SSD-5250

YOUR REF: DUBBO BASE HOSPITAL, MYALL STREET, DUBBO.

I refer to the State Significant Development placed on public exhibition for the redevelopment of Dubbo Base Hospital. Council supports the proposal and the delivery of further health infrastructure for the city. The following comments are provided to assist the Department in consideration of the proposal and to highlight a number of issues requiring further information or clarification:

A sketch is included with this statement to indicate the stormwater drainage system.

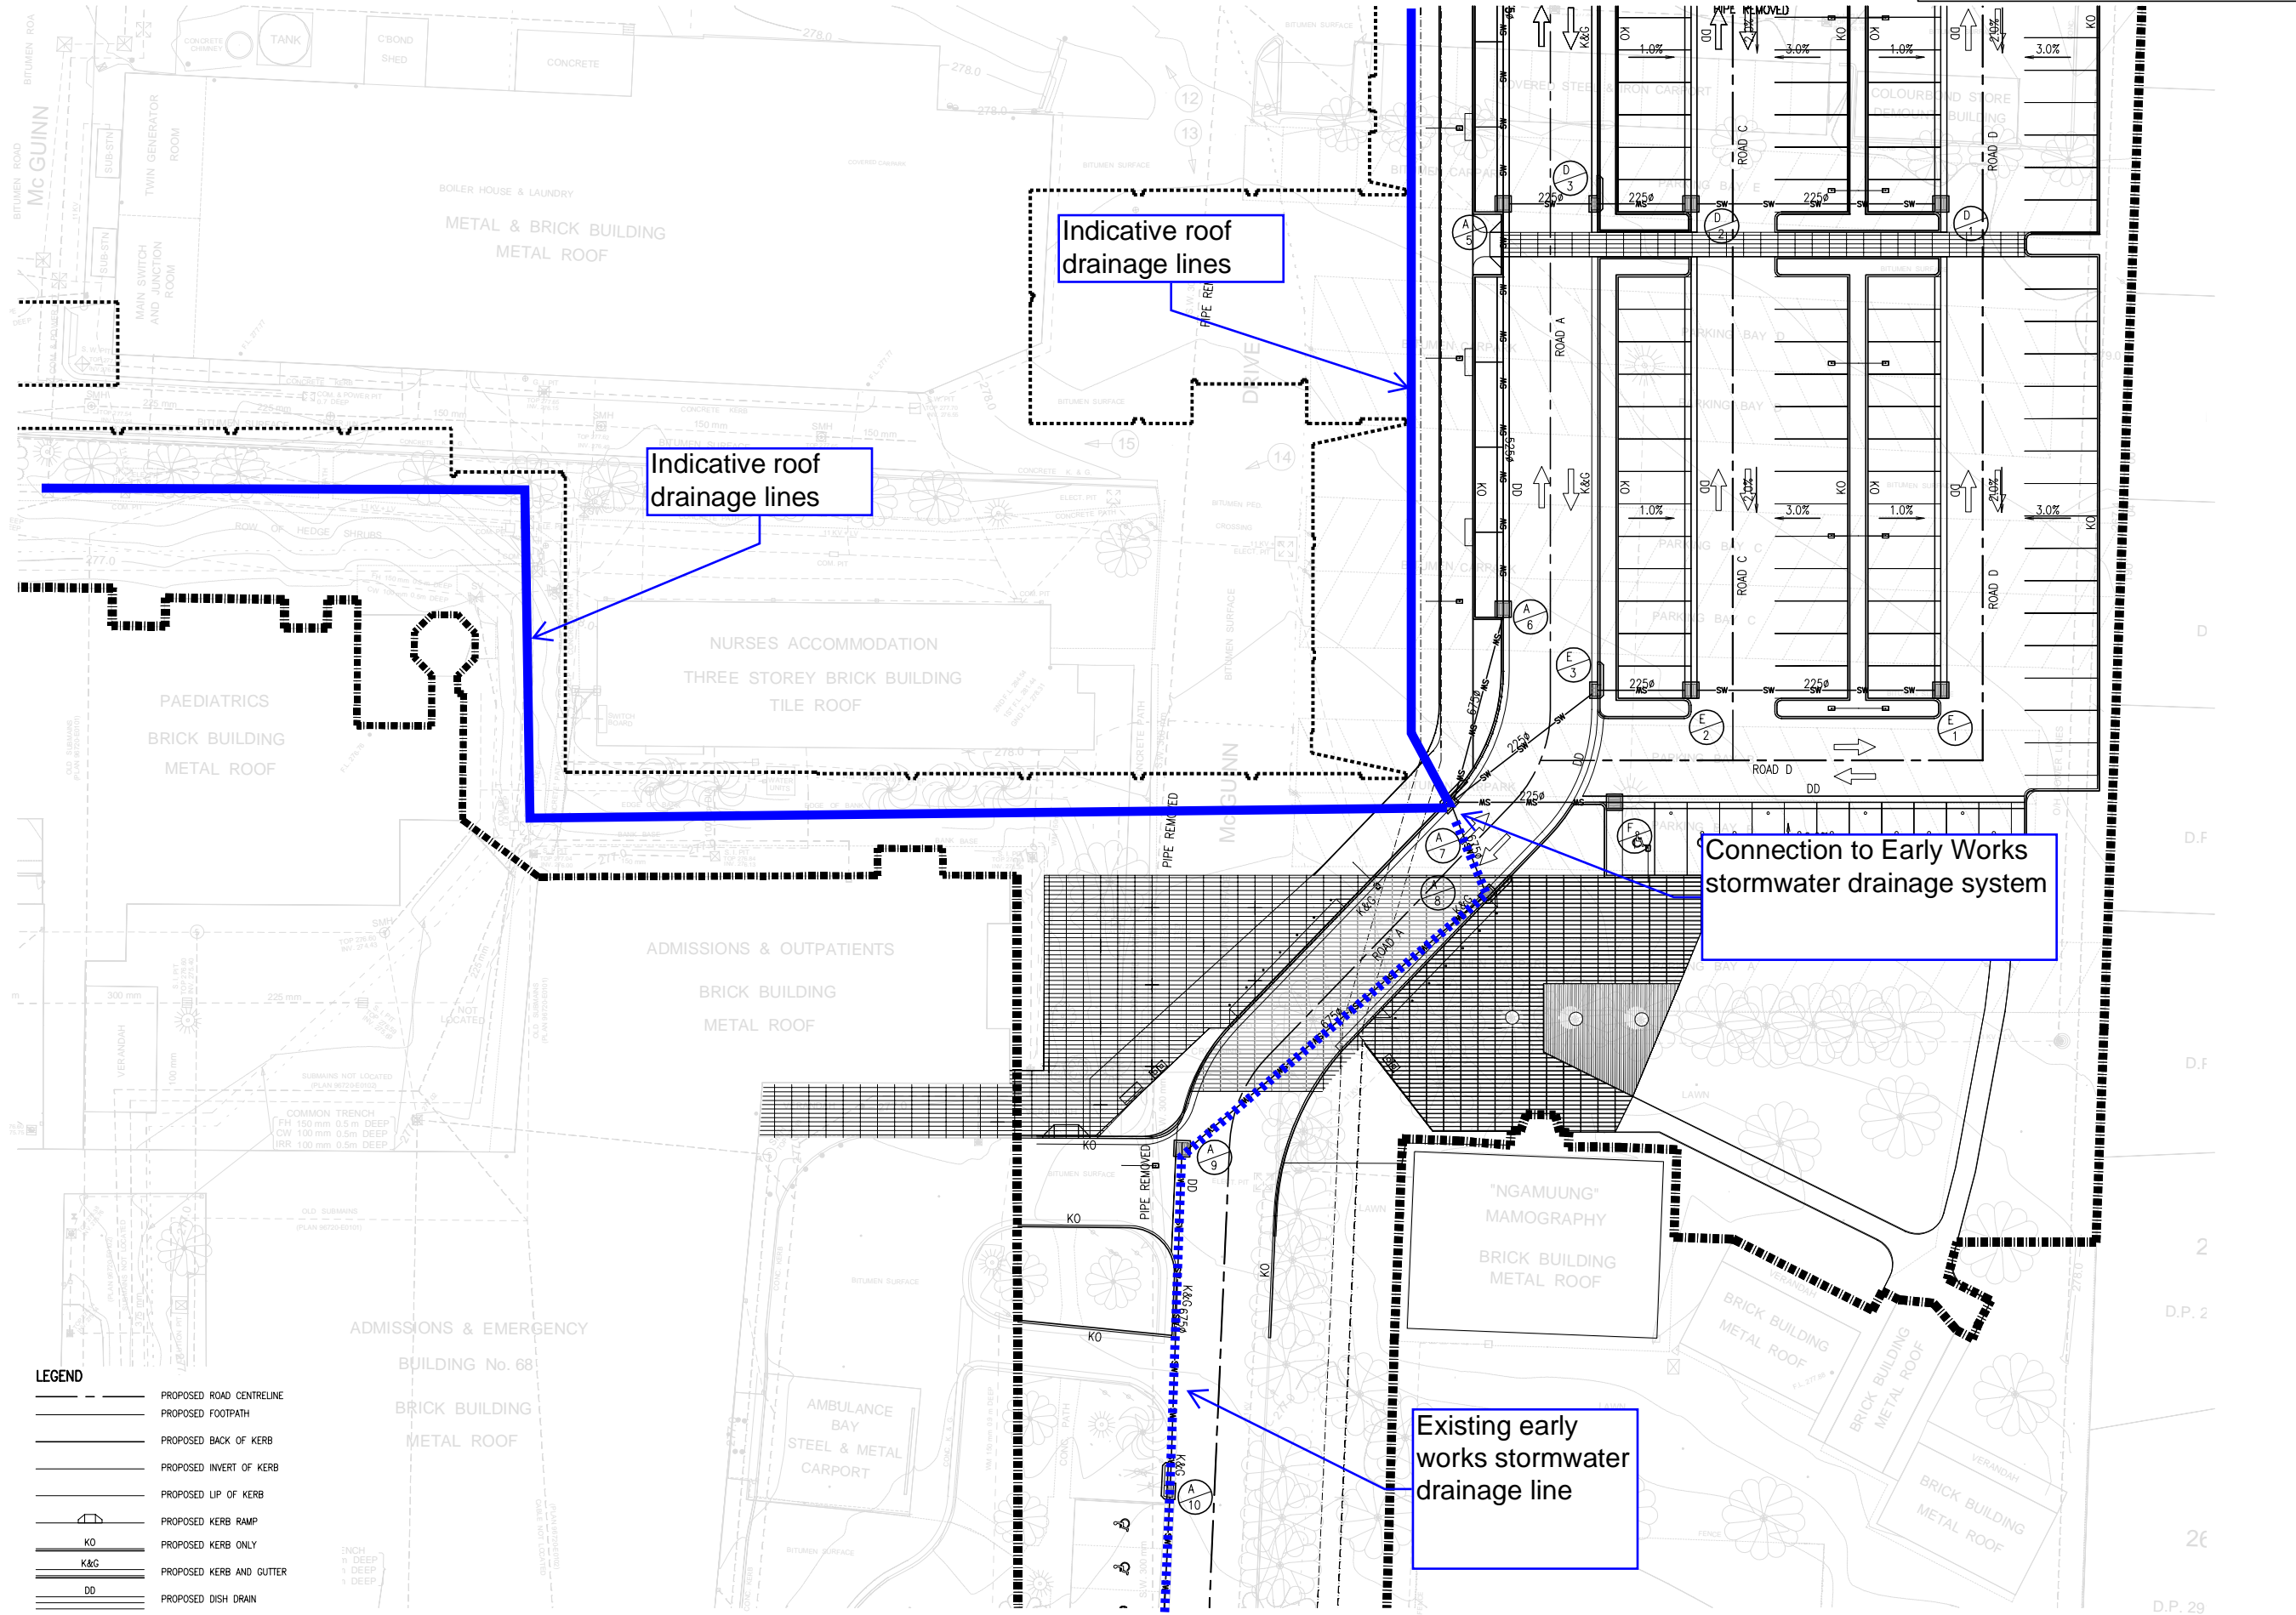
There is no information in relation to the drainage to the north towards River Street including information on water quality, gross pollutant traps, etc. Also there is no overall catchment plan supplied for stormwater management.

It is considered that the interaction of the detained flows with the existing catchment flows need to be addressed so that the peak flows do not coincide to create an issue. In addition, the overland flows along Myall Street will end up in the railway drain, which may be an issue in larger events.

The downstream underground system may not be a 1 in 10 year system. Council design standards require that this system be designed to a 1 in 10 year system.

It is unclear if the design takes into account any upstream flows from the east and whether they impact on the proposed development. In addition it is unclear if the design allows for future expansion of the site or is it expected that further development will remain within the existing building footprint.
